Application: SSI 7485

I write regarding the proposed modification to M4-M5 Link, Mod 2 The Crescent overpass and changes to pedestrian infrastructure in North Annandale, Rozelle and Rozelle Bay Foreshore area.

Figure 4-2 Pedestrian and cyclist bridge infrastructure options

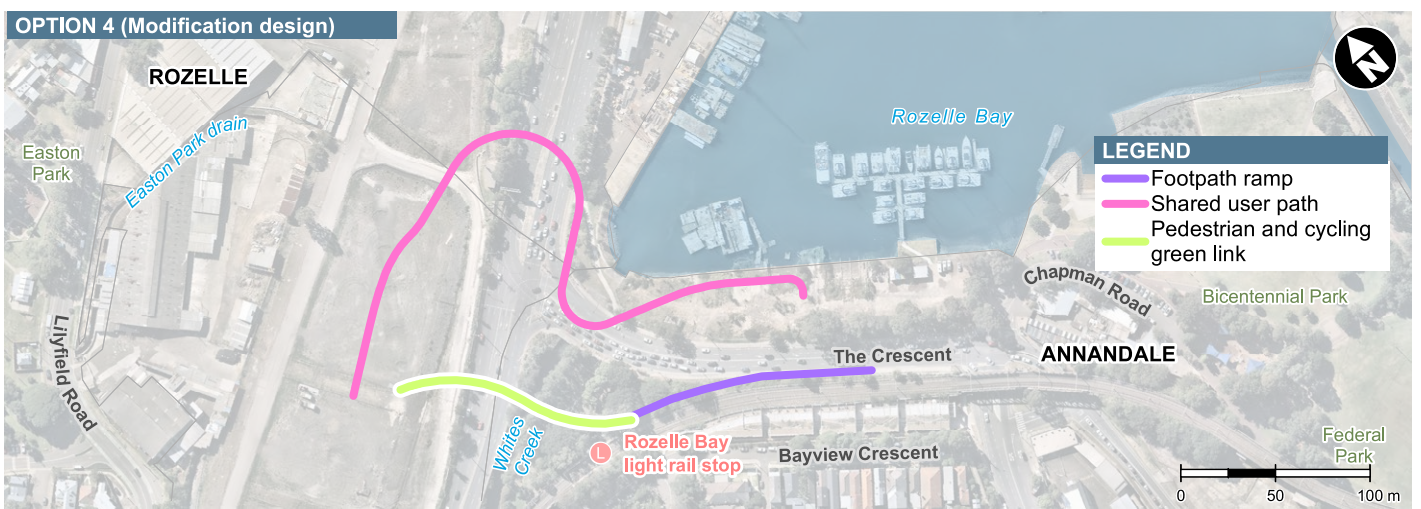
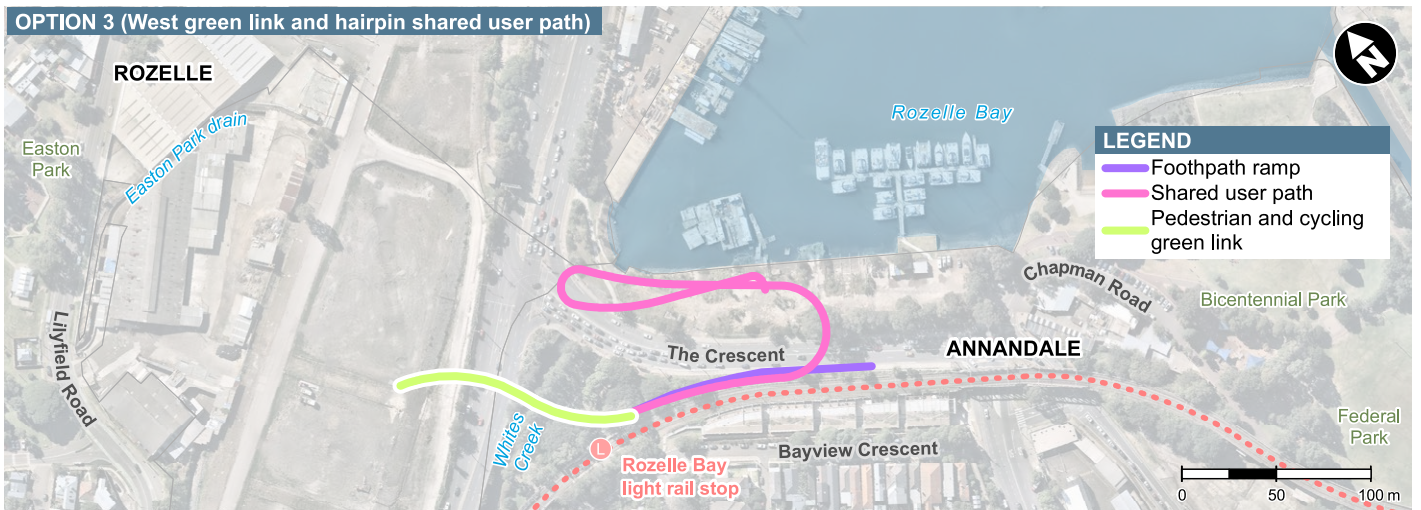
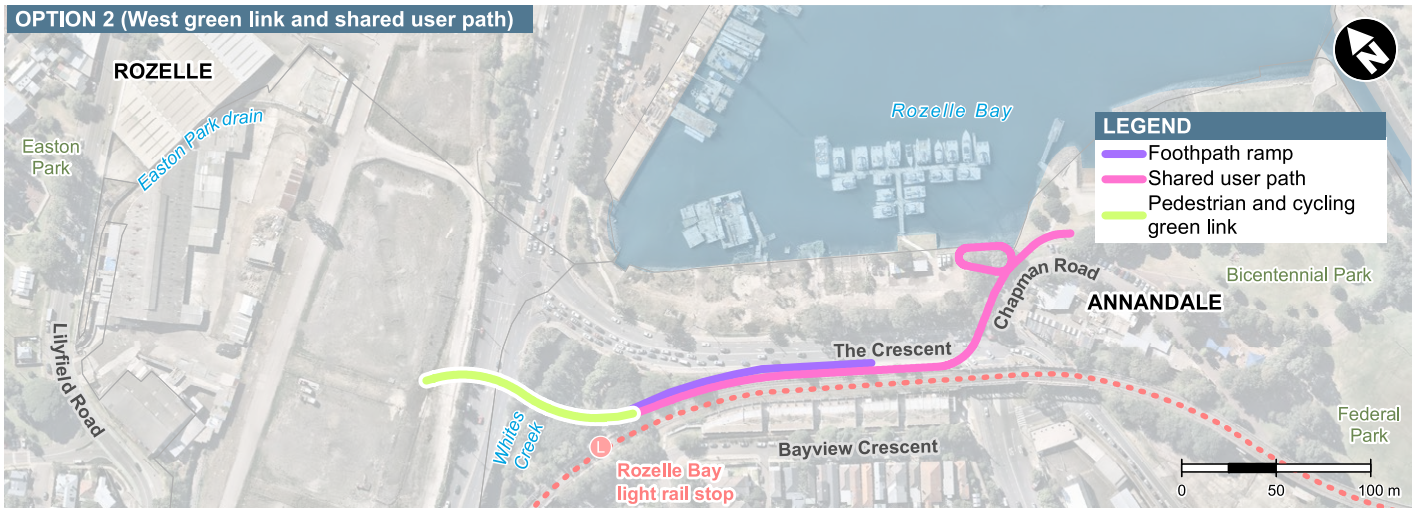
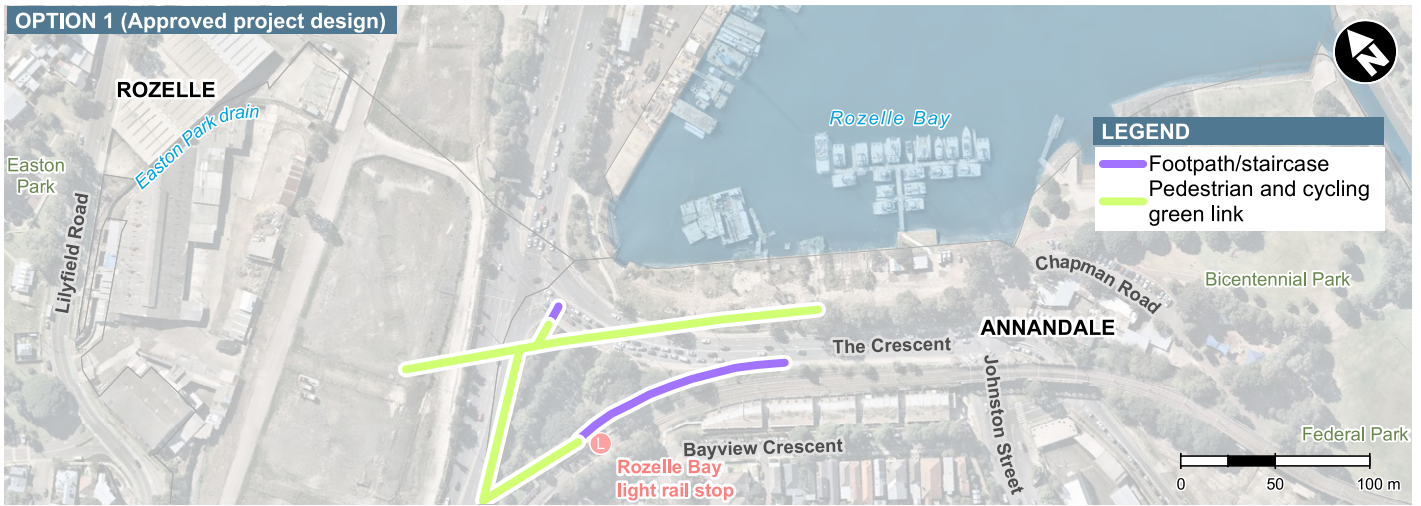
I request RMS work with the community to explore alternate design options to the proposed new car overpass design and the changed pedestrian and cyclist links. I am seeking the reinstatement of the safe, direct access from the approved EIS GreenLink to create a continuous green open space connection from the Rozelle Rail yards and Annandale to the foreshore. The GreenLink was more than just a walk way - it put people central to the design, maximising safety, and providing much needed accessible open space for the community now and into the future Bays Precinct design.

- The significantly reduced safety and increased risk for pedestrians and cyclists with removed access over The Crescent to Bicentennial Park and the increased traffic along Johnson Street.
- Being required to cross five sets of pedestrian lights at The Crescent as my option to reach the foreshore from Annandale or from Rozelle Bay light rail stop.
- Removal of direct active links to the foreshore, cutting the community off from the area and the proposed revitalisation of the entire Bays Precinct, including linking the Light Rail and Bus stops to a Ferry wharf and Metro station.
- Urban and landscape design that is being built before a finalised Masterplan for the area.
- Traffic changes that limit movements around the suburb and create further congestion in the local streets of Annandale, Forest Lodge, Glebe, Lilyfield and Rozelle with no planning to deal with these.

- Reinststate the GreenLink connecting communities and green open space from Rozelle to Bicentennial Park
- Relocate and design pedestrian and cyclist connections that are continuous, safe and direct.
- Design the modification infrastructure and active links in response to the character of the suburbs, the location of the foreshore and it's potential future development.
- Provide pedestrian and cyclist paths that maximise people safety and do not force them onto busier streets, unsafe concrete plazas and caged walkways.
- Integrate active and direct connections to all active transport - including the future Metro West and Foreshore Ferry Wharf

Figure 4-3 The Crescent, Johnston Street, Chapman Road intersection options

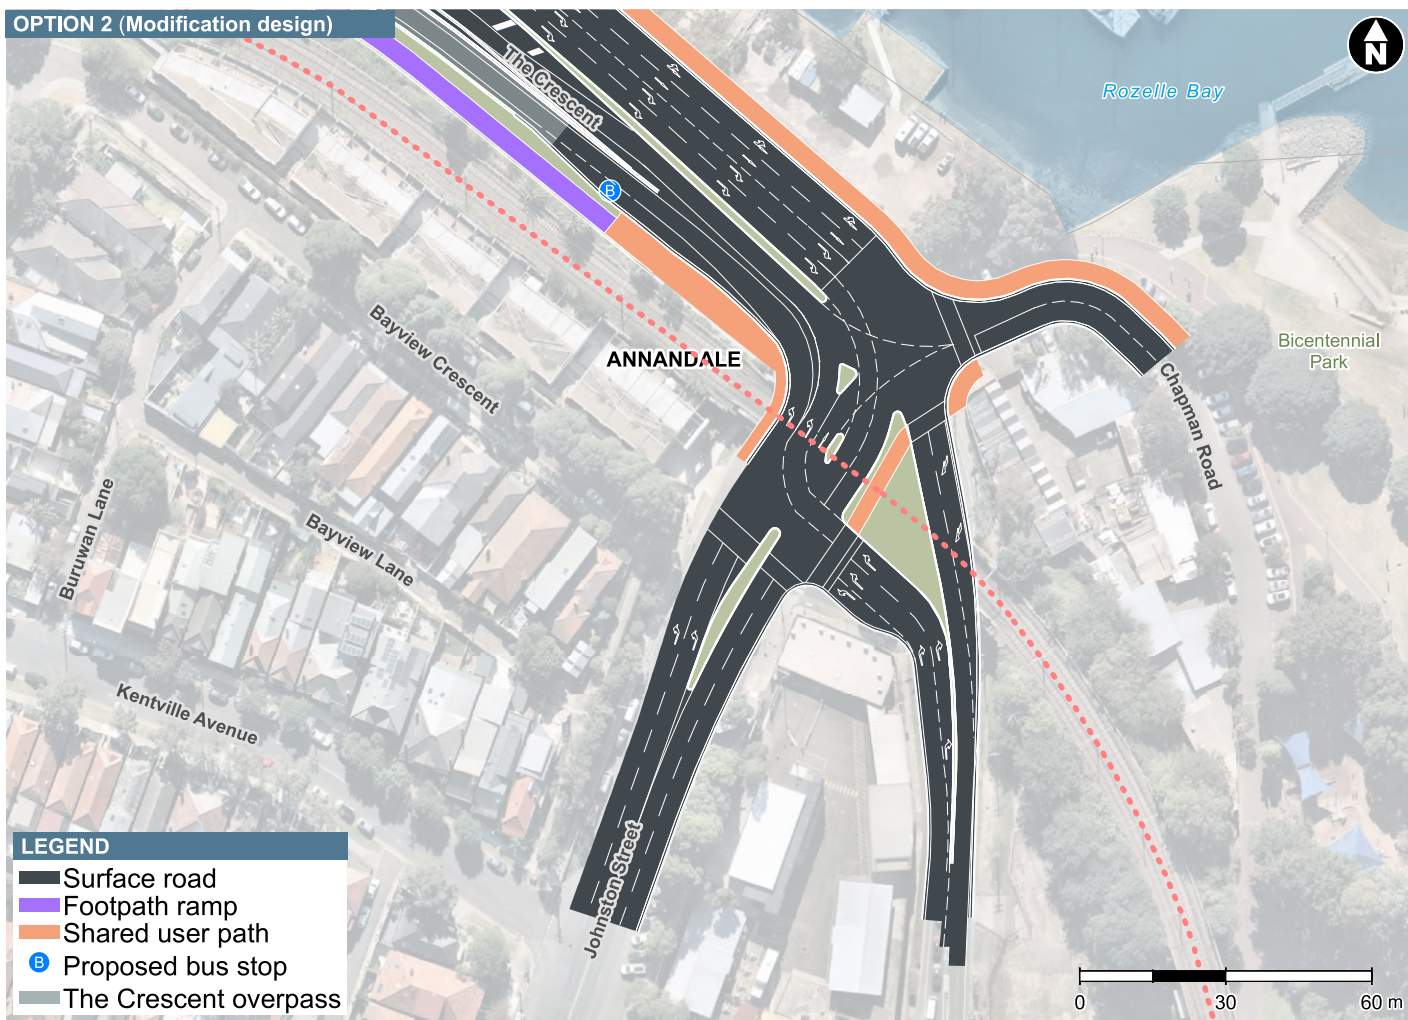
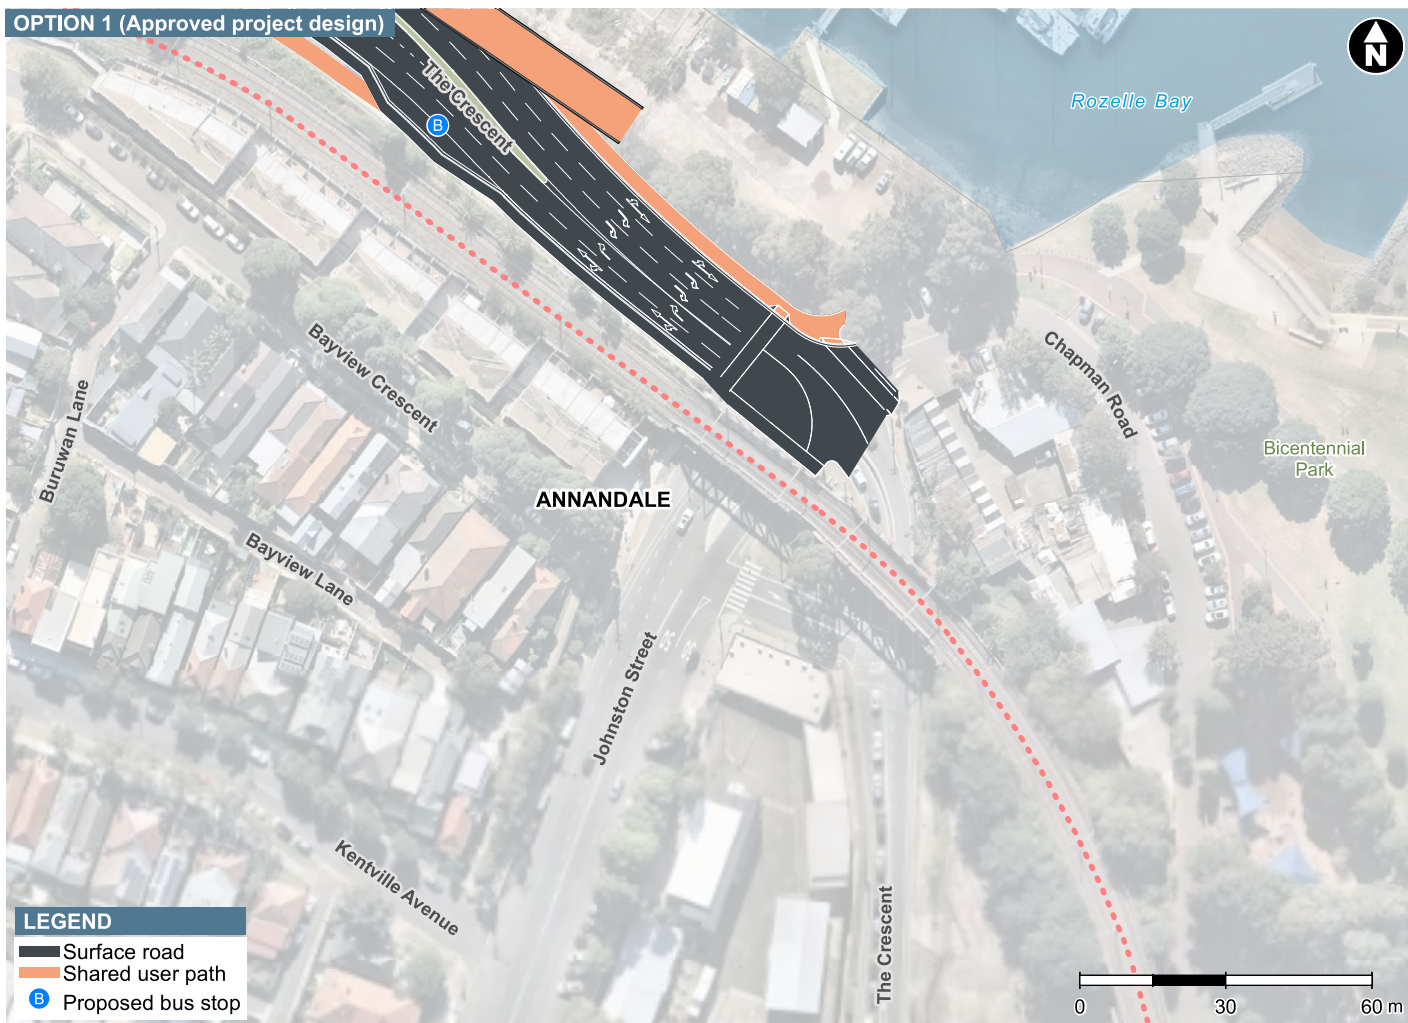
I am concerned about the increased traffic on Johnston St, Annandale as there are 3 schools on Johnston St which will suffer with increased pollution and noise and less safety.
